Final Report - Corrections Required **Application No. DEPN-26-0013**

Description : Development Plan to establish internal roadways and lots. No end-users are proposed with this development plan application.

Address : 0 BRADLEY RD Colorado Springs CO

Document Filename : DP_V2_06-24-26

DEVELOPMENT PLAN
STORM PLAN

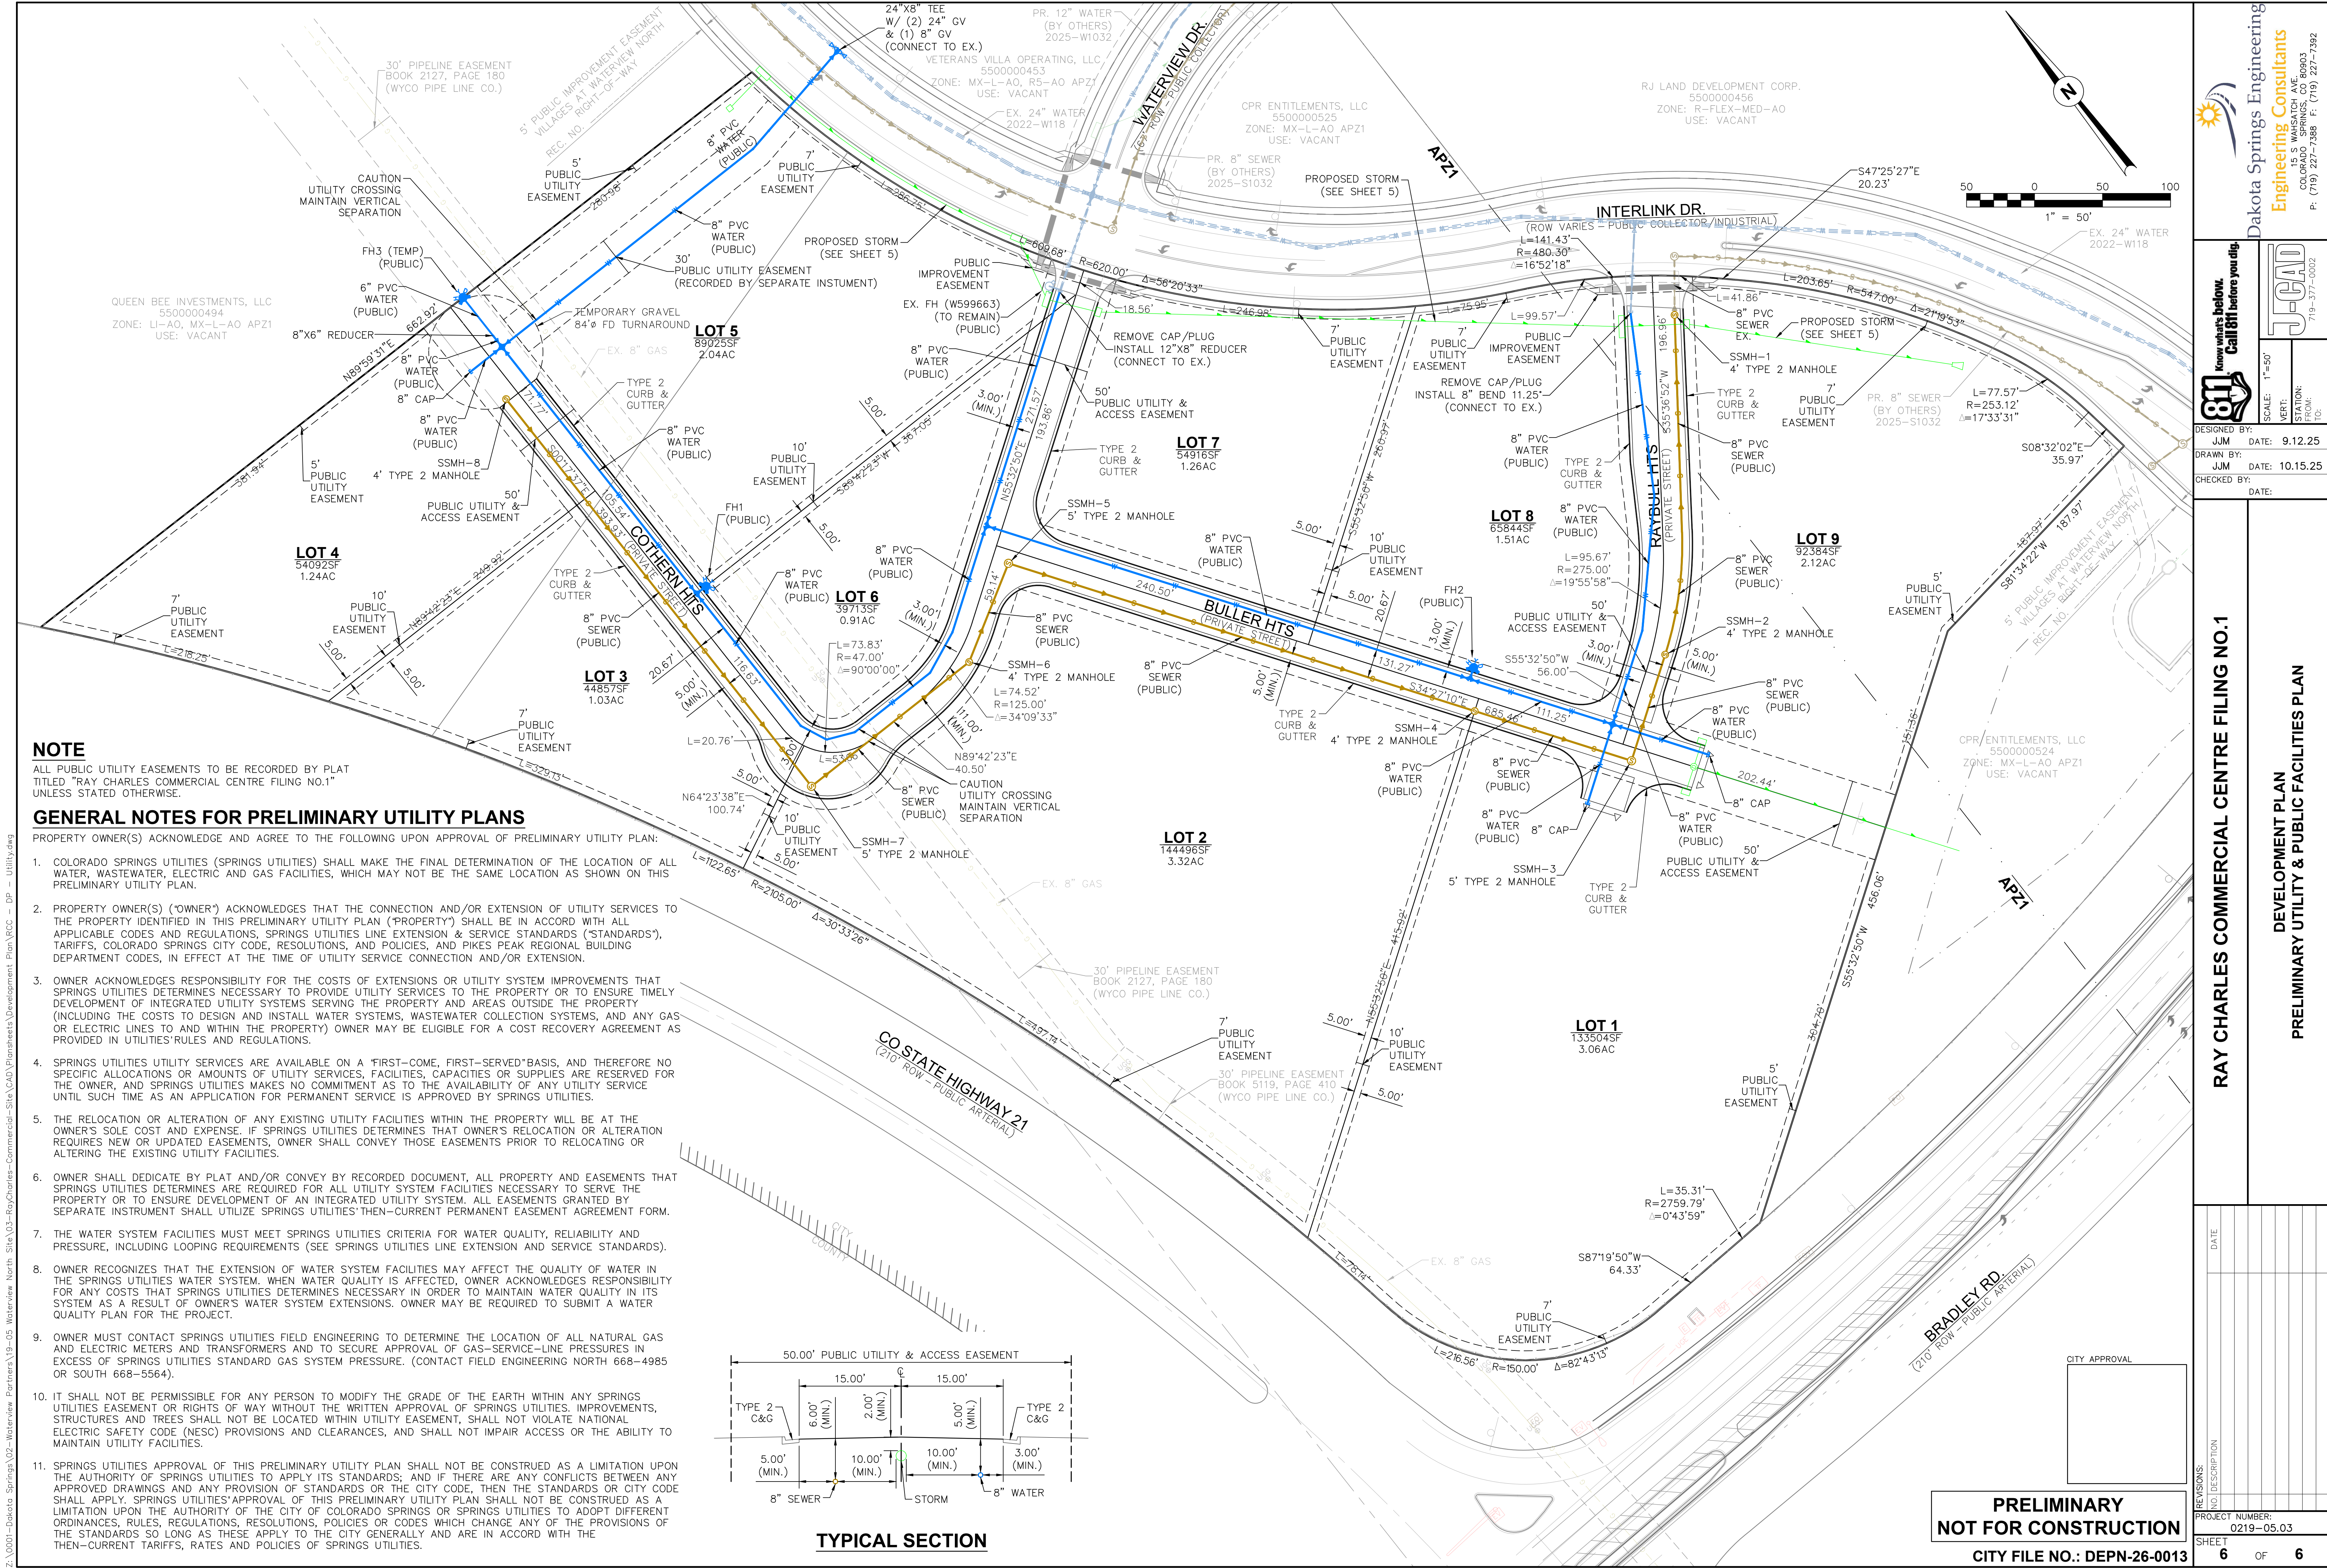
Comment ID	Page Reference	Reviewer : Department	Review Comments
42	5	Sara Rivera : City Engineering - SWENT	Info Only: The City of Colorado Springs (City) Public Works Department issued updated standard details for inlets on July 8th, 2024. The updated inlet details are available here: Link . All proposed inlets in the City of Colorado Springs must conform to these updated inlet details. Please note that these five (5) new City standard inlet types are similar to other previously acceptable inlet types, as can be seen in SWENT's May 2025 Policy Clarification, "Hydraulic Modeling for Colorado Springs Standard Inlets" available here: Link .
43	5	Sara Rivera : City Engineering - SWENT	All proposed inlets must meet one of the five (5) new / updated City standard inlet types. See related Info Only comment for more information.
45	5	Sara Rivera : City Engineering - SWENT	Label all existing and proposed drainage infrastructure with size and ownership (private or public).

47	5	Sara Rivera : City Engineering - SWENT	The offsite disturbance associated with utility installations must be included in the total disturbed area. In the FDR, areas of disturbance for offsite utility installation can be excluded from the total disturbed area as it applies to the Four Step Process, but this exclusion must be clearly documented. Please reach out to the Lead Reviewer if there are questions on how to show this. For the GEC and CWMP this disturbed area must be shown and included. This area cannot be excluded in these plans/reports.
69	5	Sara Rivera : City Engineering - SWENT	Any storm pipe that is located outside of the ROW and in private property must be labeled as private. If this is owned by a Metro district, this should be labeled as private.
73	1	Joel Dagnillo : City Engineering Dev Review	Please remove Note 23
72	2	Joel Dagnillo : City Engineering Dev Review	Previous comment partially addressed -Please also label and call out all public improvements along Bradley Rd. (such as sidewalk, curb/gutter, pedestrian ramps) to be installed by the Metro District. These improvements are shown on separate City-approved street construction plans.

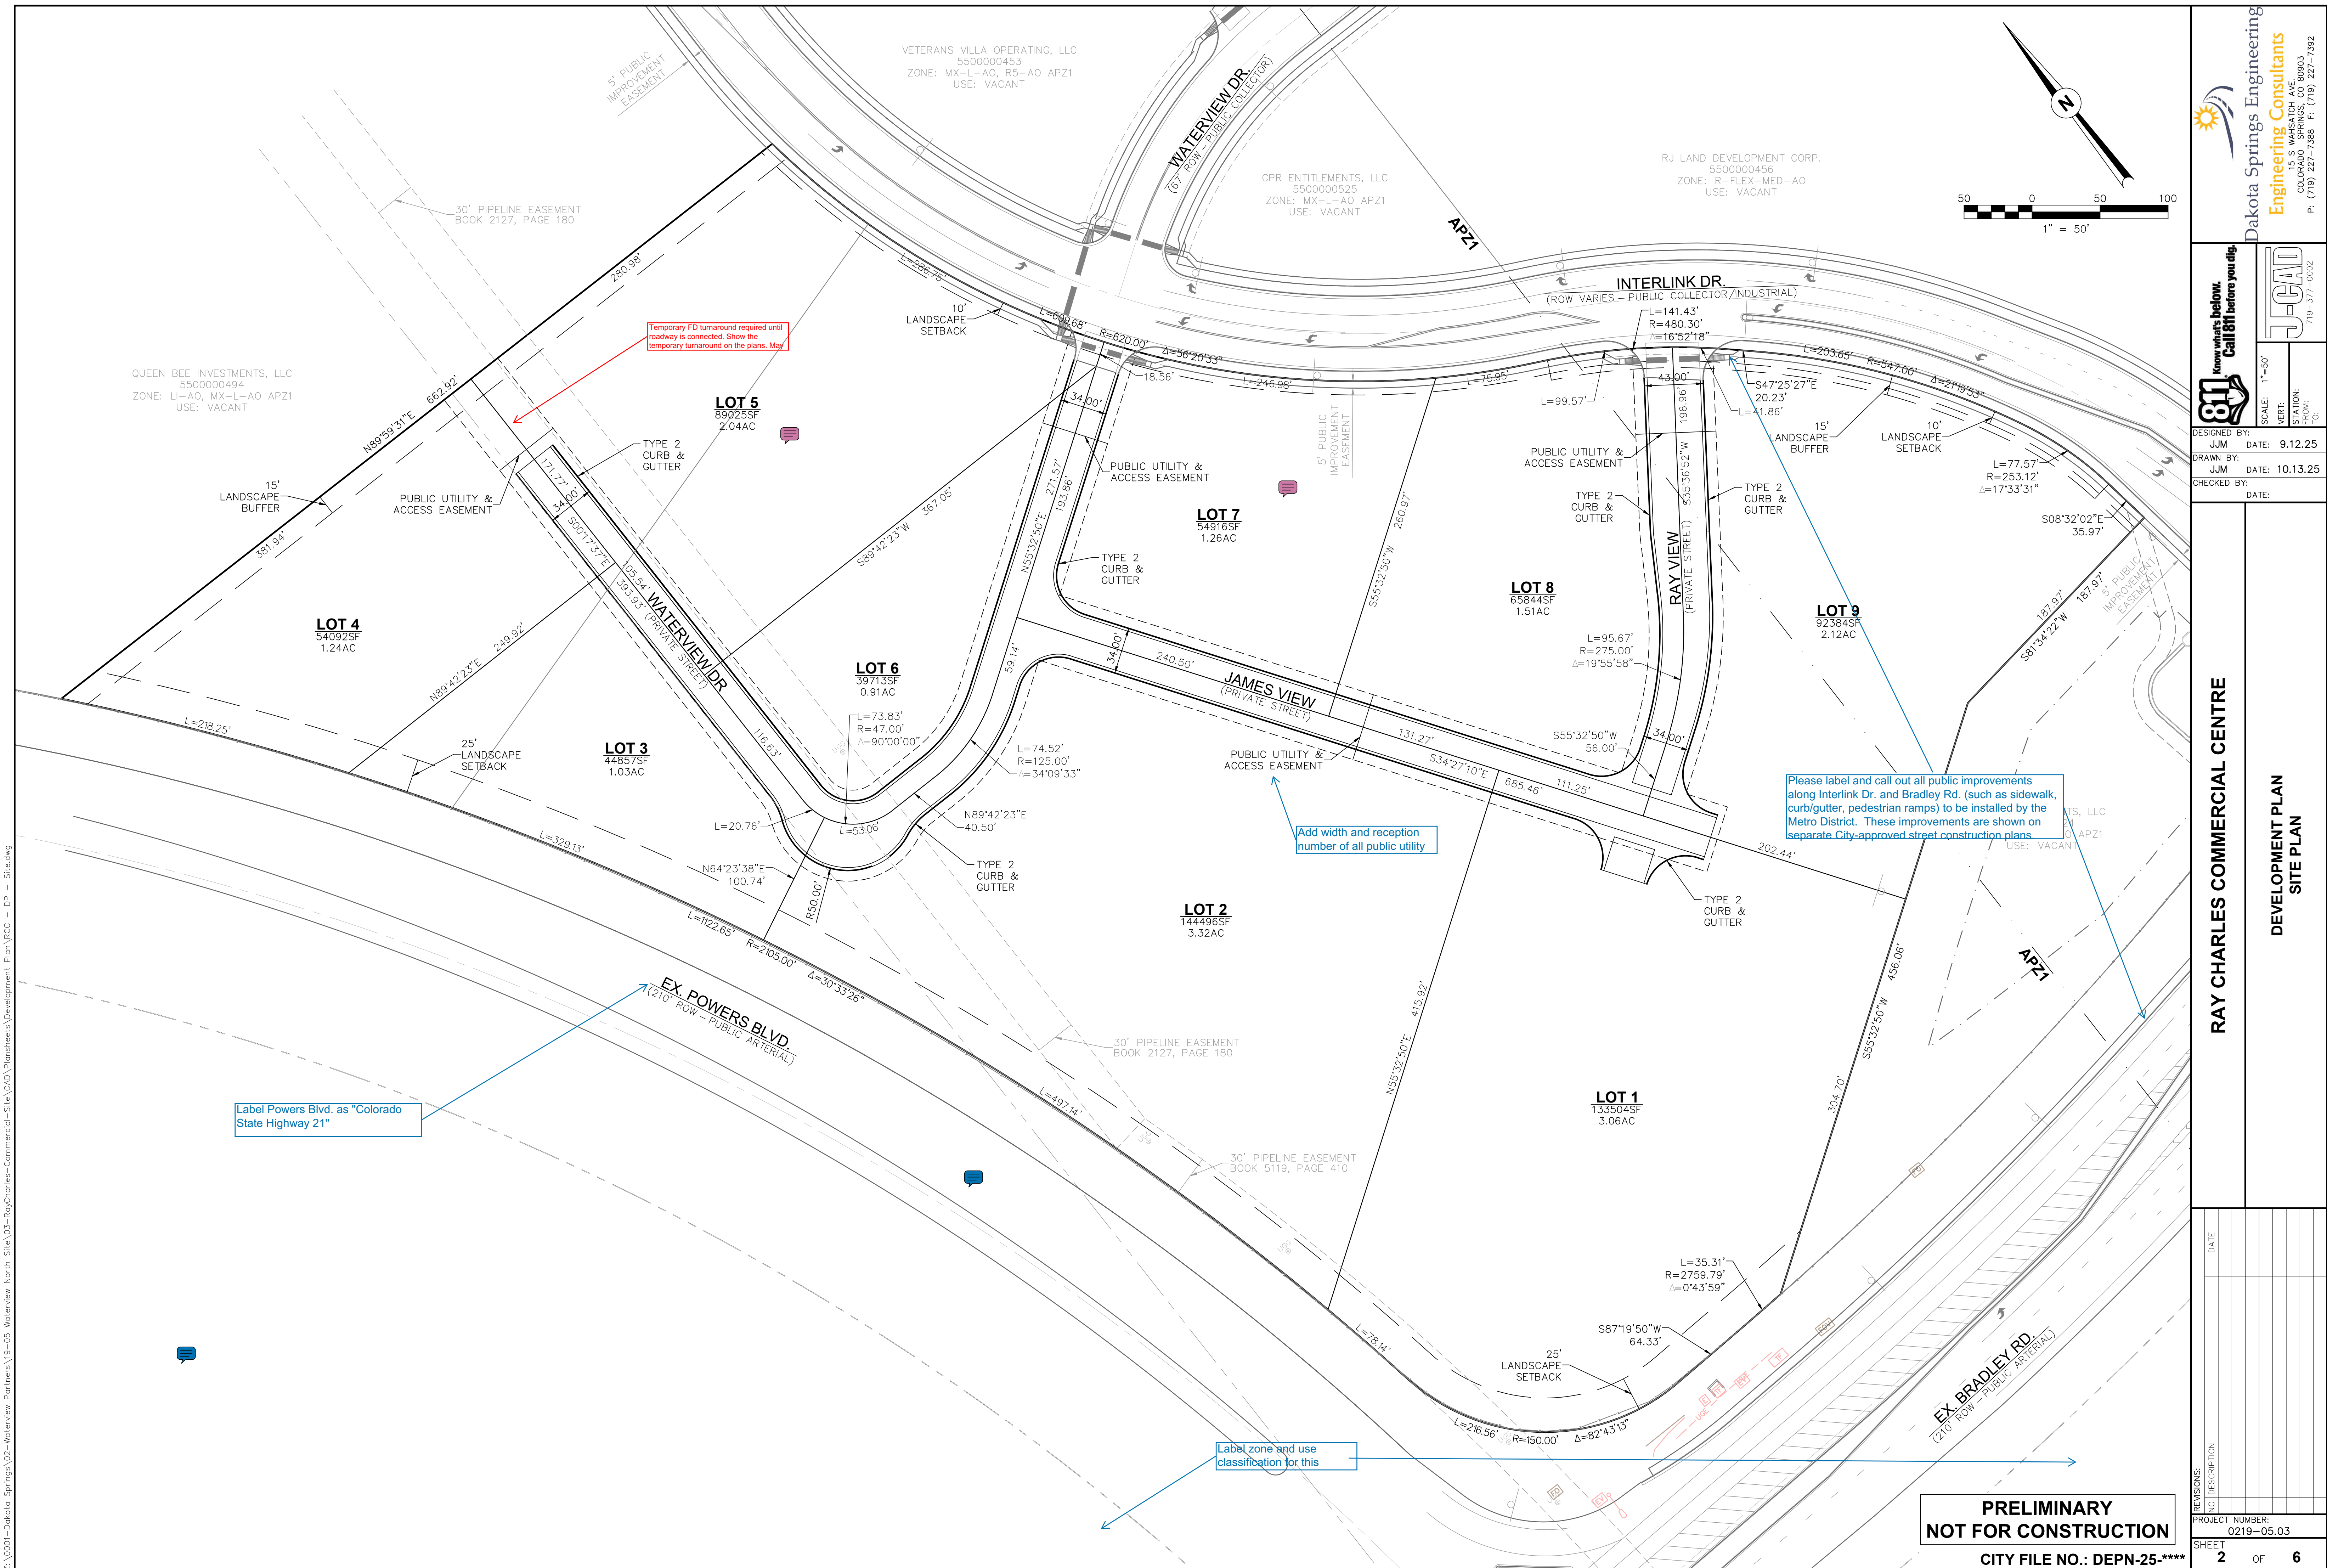
74	6	Mike Gackle : Col Springs Utilities	Lots 3,4,5 and possibly Lot 6 cannot have Construction Plans approved until the water main has 'Looping' provided for redundancy.
76	6	Patrick Dosch : Col Springs Utilities	Wastewater main to C&G is a 5' minimum horizontal clearance. Please revise, typical
77	6	Patrick Dosch : Col Springs Utilities	Please upload the HGL and WWMFF response documents.
78	6	Patrick Dosch : Col Springs Utilities	Previous comment not addressed: Please provide the street cross section detail from the LESS
82	1	Drew Foxx : Planning	Revise: Future development of each lot shall be subject to additional development plan applications for review by City Planning.
83	1	Drew Foxx : Planning	Remove due to revisions to note 28.
84	1	Drew Foxx : Planning	Revise note 21: This is not a correct statement. There are several uses that are not permitted within the APZ-1 within the industrial/commercial land use categories. Please discuss with Chris Padilla (CS Airport Planner) as to what note they would like on this cover sheet addressing the APZ-1 Overlay.
